October 26, 2022

Re: SAIA – *Technical Review 1*
PA 22025

SHEET NUMBER
C4.0

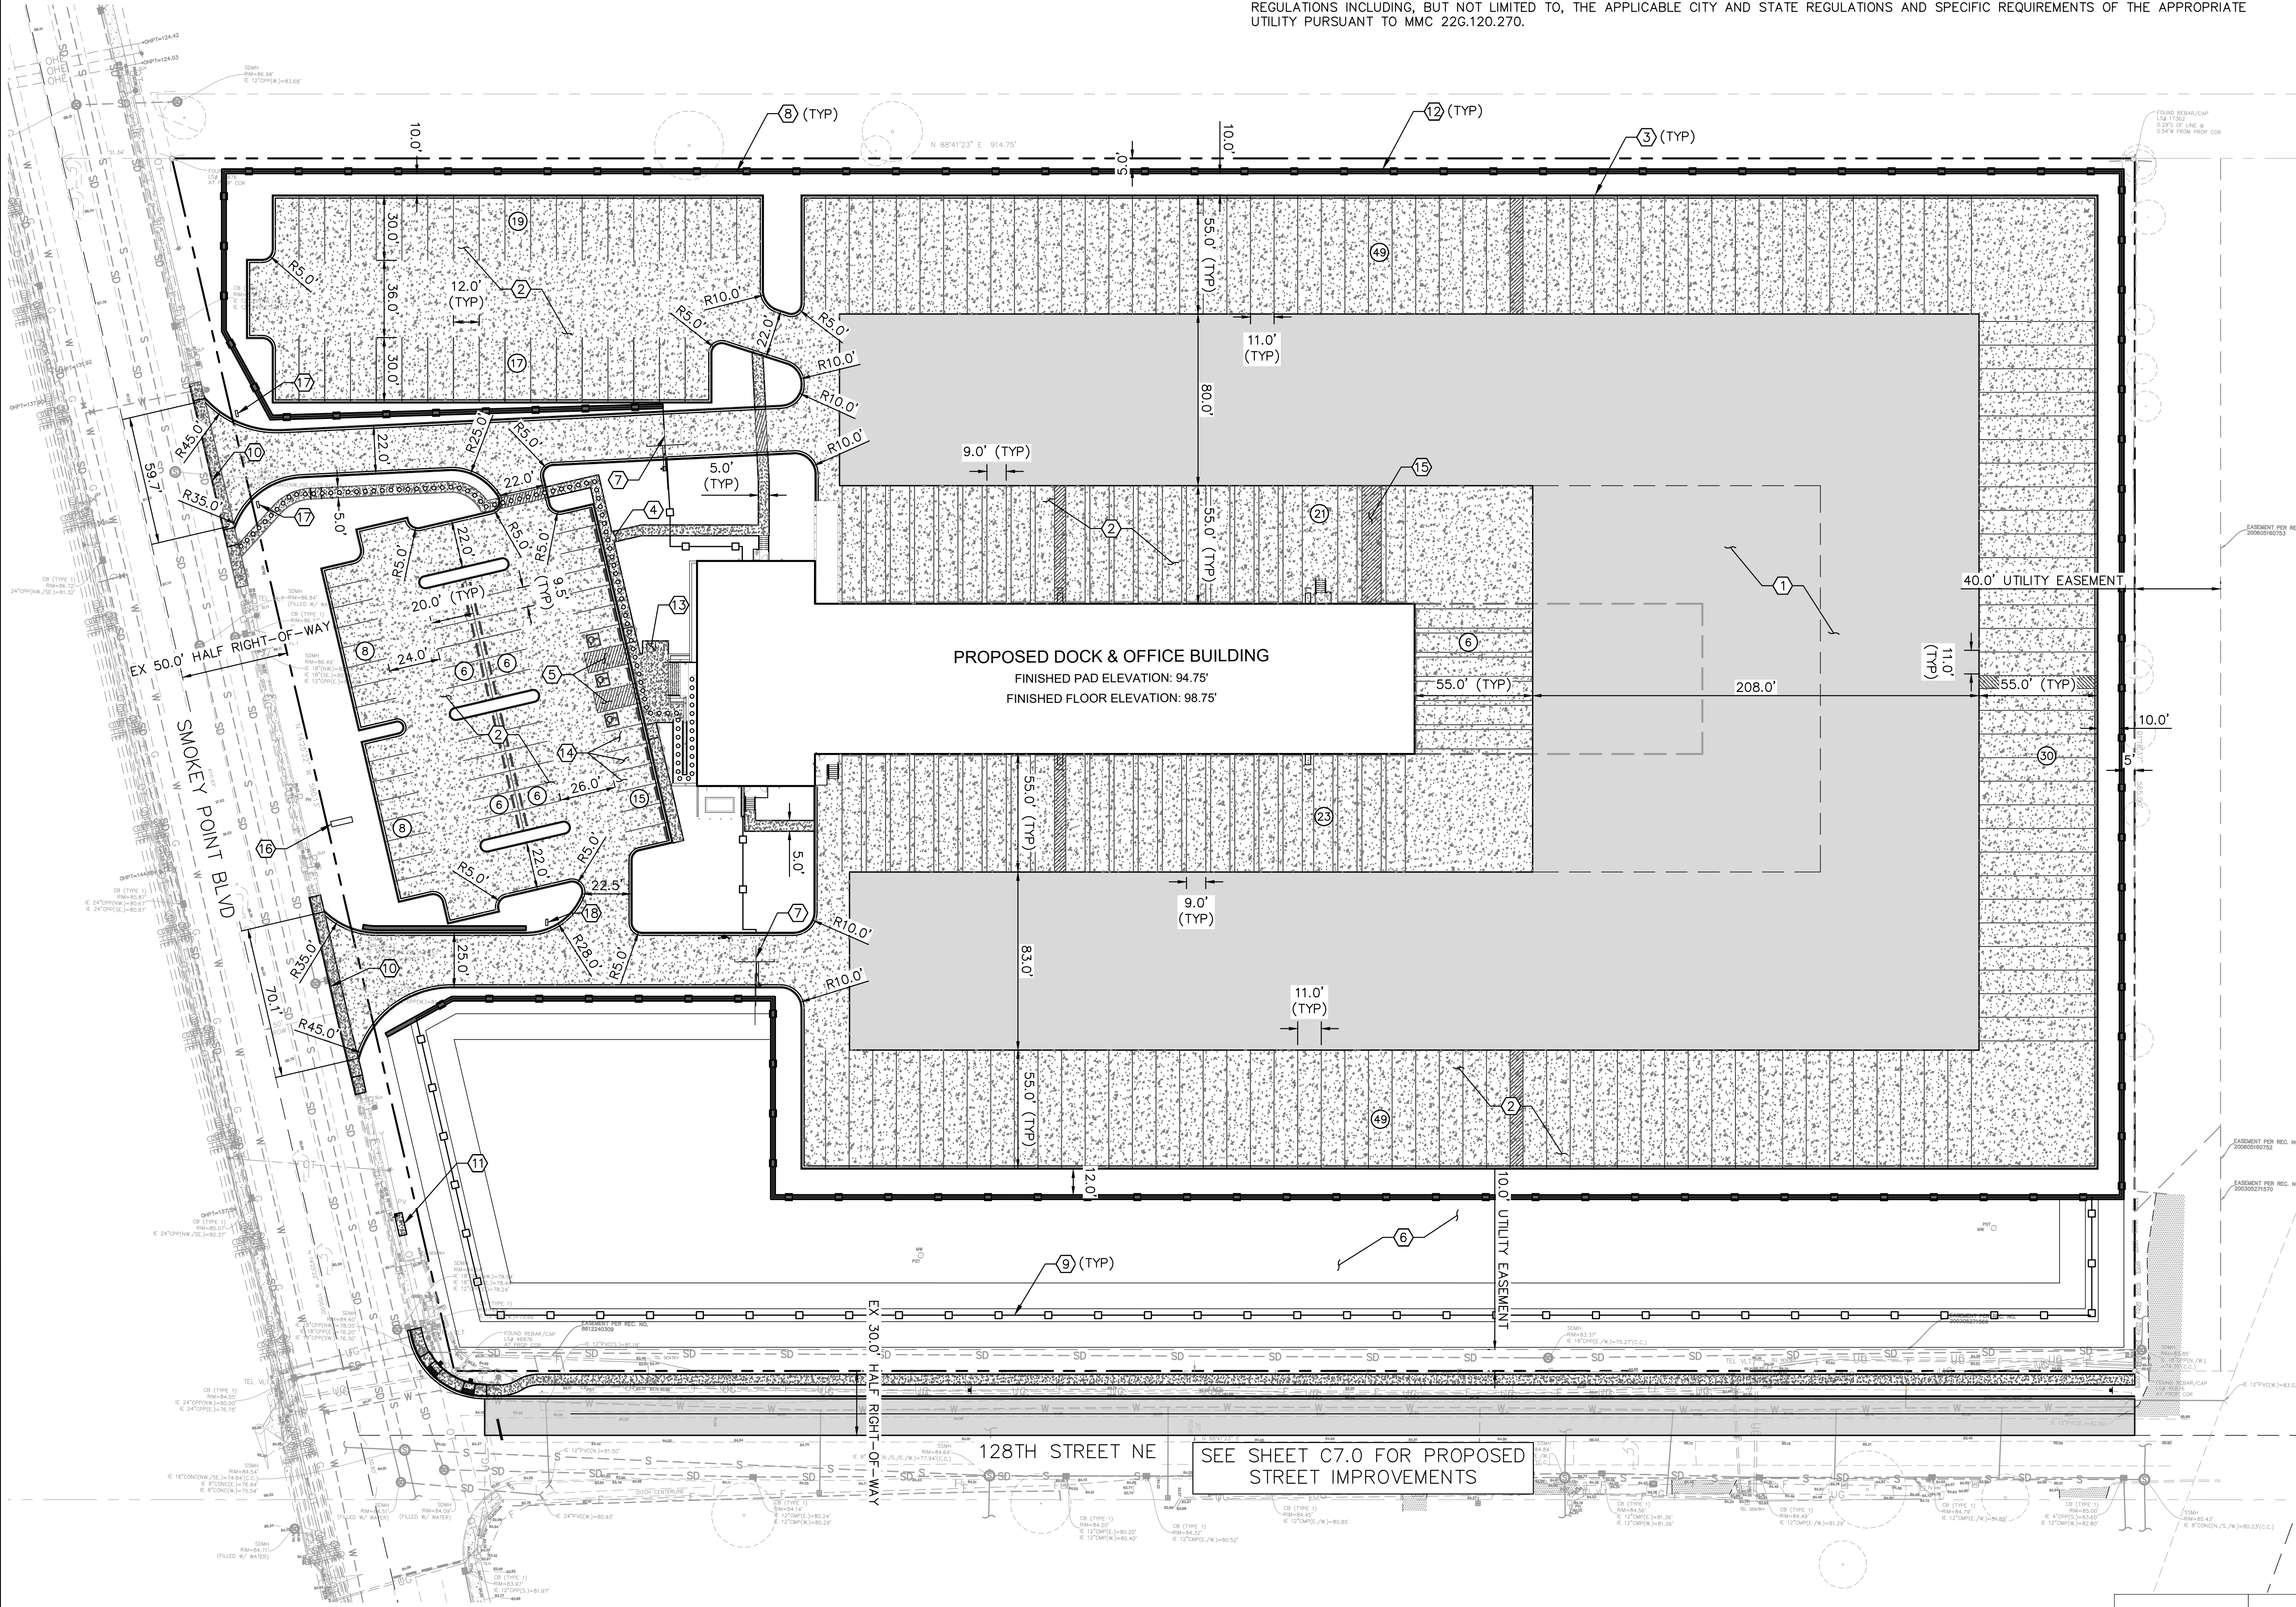
2. Amend Sheet C4.0 as follows:
 - a. **TR1 Comment:** The minimum drive-aisle width on the northern entry way, access to the employee parking area and within the employee parking area shall be 22’.

Response: Drive-aisles at the northern entry way and employee parking lots have been widened to minimum 22’.
TR2 Comment: The access entry to the employee parking area on the north still measures 20’.
